Recommendation Report for Planning Permission for Works or Extension to a Dwelling

REF NO: WA/114/21/HH

LOCATION: 27 Oaktree Cottages
Barnham Lane
Walberton
BN18 0AY

PROPOSAL: Erection of single storey rear extension.

PROPOSED ELEVATIONS.
1:100

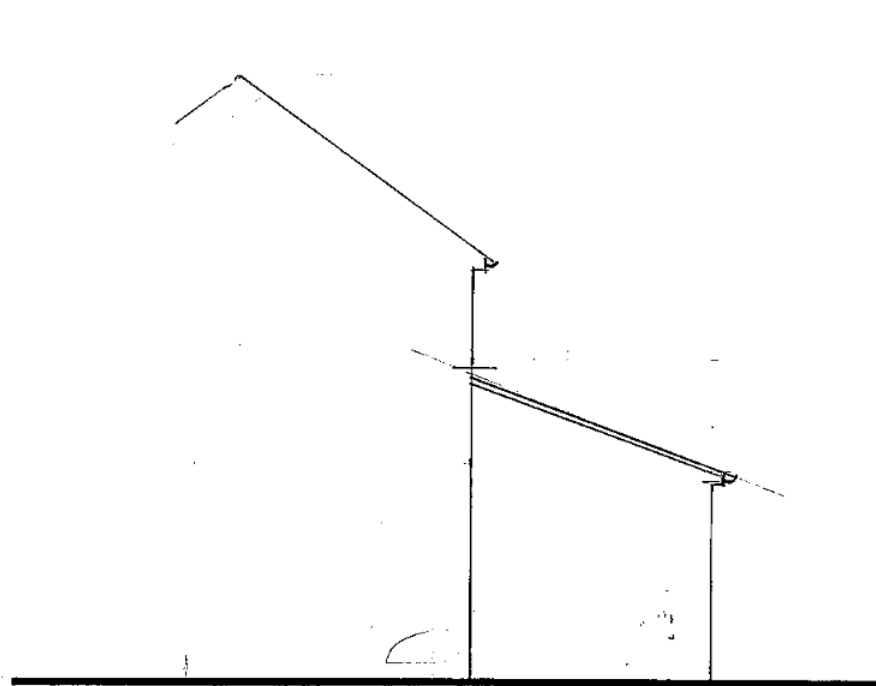
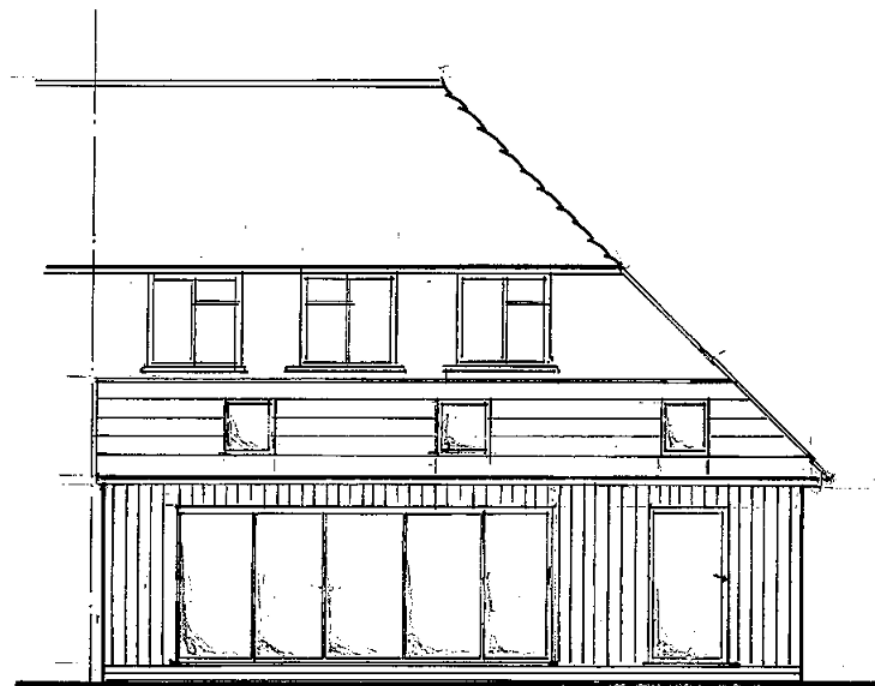
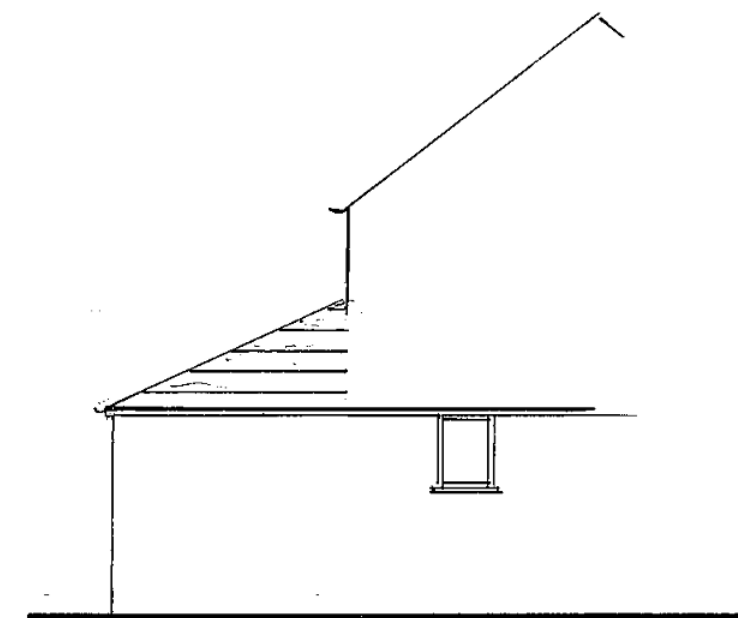
The attached neighbour dwelling is the only property of concern when considering residential amenity impacts due to the siting of the property. The extension is separated from the western site boundary by 0.15m which borders the attached neighbour dwelling and the rear extension is to reach a height of approx. 4m featuring a pitched roof design with eaves that sit at approx. 2.6m.

Section M of the Arun Design Guide sets out the 45 degree rule when considering light accessibility. The height and design of the roof at the western site boundary is such that there would be an intersection of this 45 degree rule. The intersection is minimal and not considered to give rise to any significantly adverse impacts by way of overshadowing or loss of light on the attached neighbour dwelling due to the single storey nature of the proposal.

Section M of the Arun Design Guide sets out the 60 degree rule when concerning rear viewpoints from neighbour dwellings and single storey rear extension proposals. The depth of the proposal is such that the 60 degree sightlines from the rear of the attached neighbour dwelling are not intersected. Therefore, there are no adverse impacts by way of overbearing.

Featured within the proposal are a set of glass sliding doors and 3 No. rooflights to the rear of the extension. The set of glass doors look out to the rear garden and give no rise to adverse impacts by way of overlooking. Equally, the 3 No. new rooflights give no rise to adverse impacts by way of overlooking due to their height of approx. 3.2m above finished floor level.
